TECHNICAL NOTE

Job Name: Up to 60 dwellings and public open space with associated works - Land and former Buildings UH11 442 456 466 467 468 470 471 481 492 493 529 593 596 Dow Street Upper Heyford **Planning Reference 13/1811/OUT**

Subject: **Response to Transport Comments Made in Planning Response 12th February 2014**

FIGURE 3

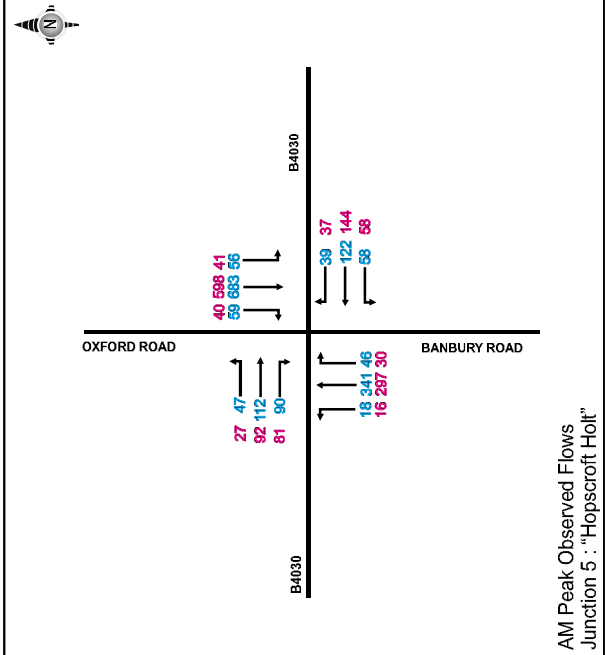
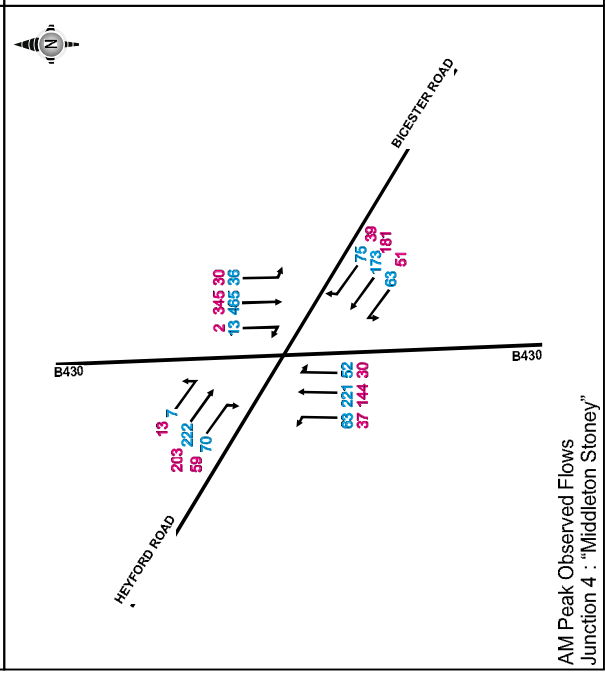
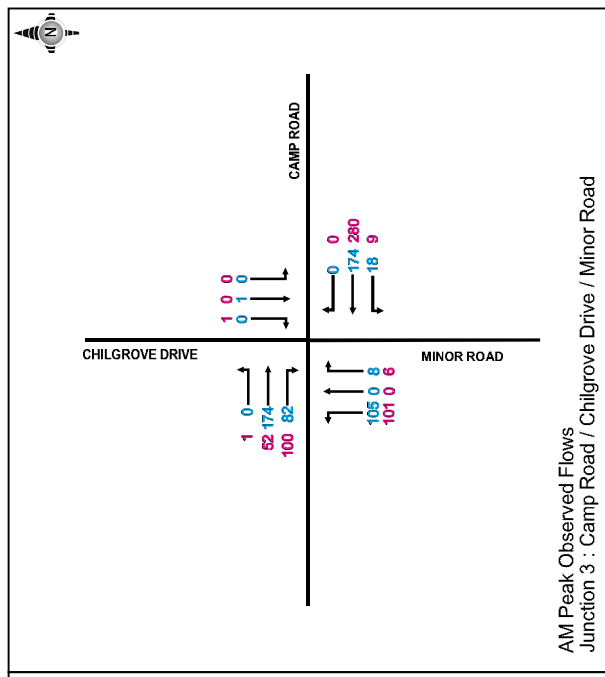
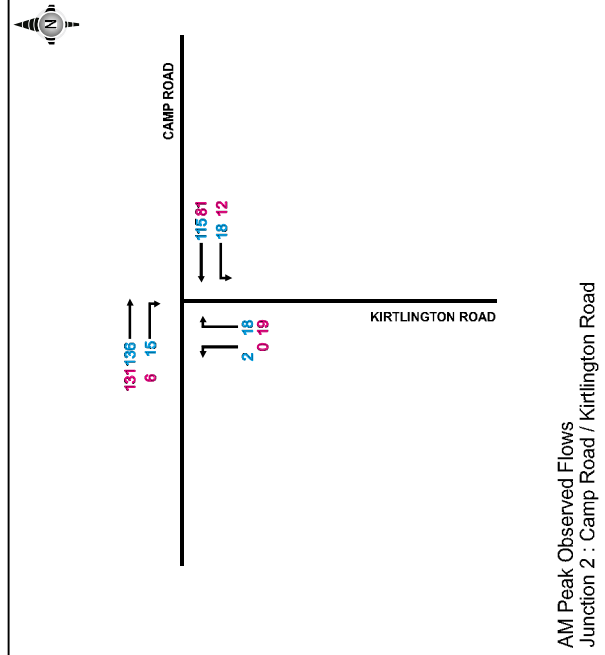
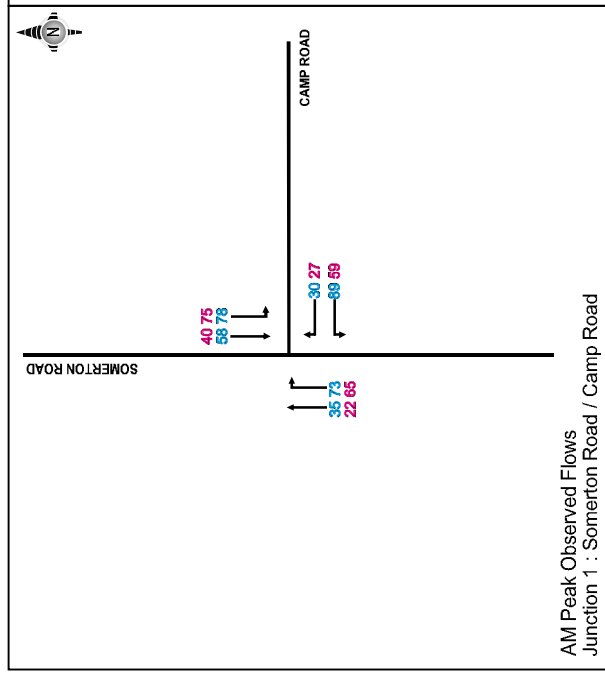
13.	<p><i>Figures 4 and 5 in the TS appendix have a number of errors when compared with the manual count data. Also Figure 5 repeatedly refers to AM peak when actually it is looking at the PM peak, which is confusing.</i></p> <p>Agreed there do appear to be errors and Figure is titled PM Peak although individual junctions are labelled AM Peak. These will be updated and attached to this note at Appendix D.</p>
